RE: Bishops Compound (File: G12D032)
Drainage and Grading Plan, Engineer's Stamp Date 10-3-2016
Supplemental Calcs, Engineer's Stamp Date 9-21-2016

Based upon the information provided in your submittal received 10-4-2016, the above referenced plan is approved for ESC Permit (Grading Permit) with the condition that an ESC Plan be submitted and approved.

Project Title: Bishop's Compound Building Permit #. _____ City Drainage #. G12/DO32

SECTION B-B

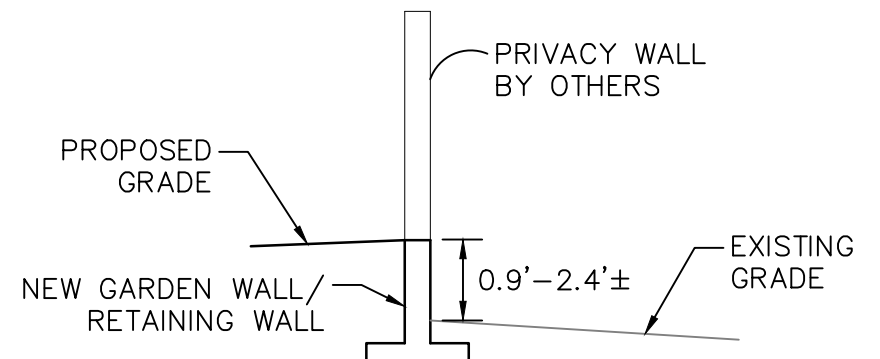
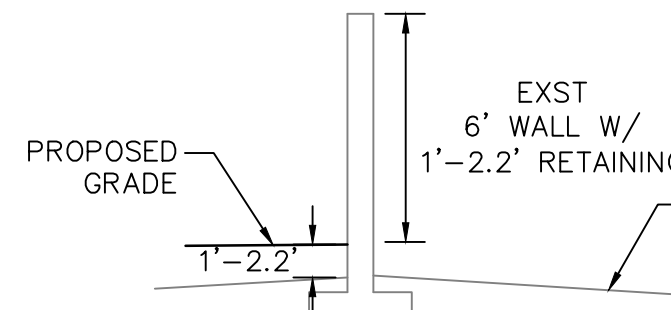
- What is on Sheet 6? It is blank.
- You will need some type of transition and transition length called out between cross-sections that change along the same road. What is the transition length and where is it between Section B-B and C-C? If the cross slope of the road changes, there has to be some type of transition. (Sheet 7)
- Between Section A1-A1 and A2-A2, what is the transition length and transition? You are transitioning from 0.5% to 2% cross-slope. (Sheet 7)
- Sheet 8 – There is no tie from stationing to benchmark, or provide a northing and easting for the beginning and end of construction.
- Sheet 10 – Remove and replace brick pavers – Call out std. detail or provide detail?
- 5" PCC (Sheet 11) – What is standard detail/ detail for this?
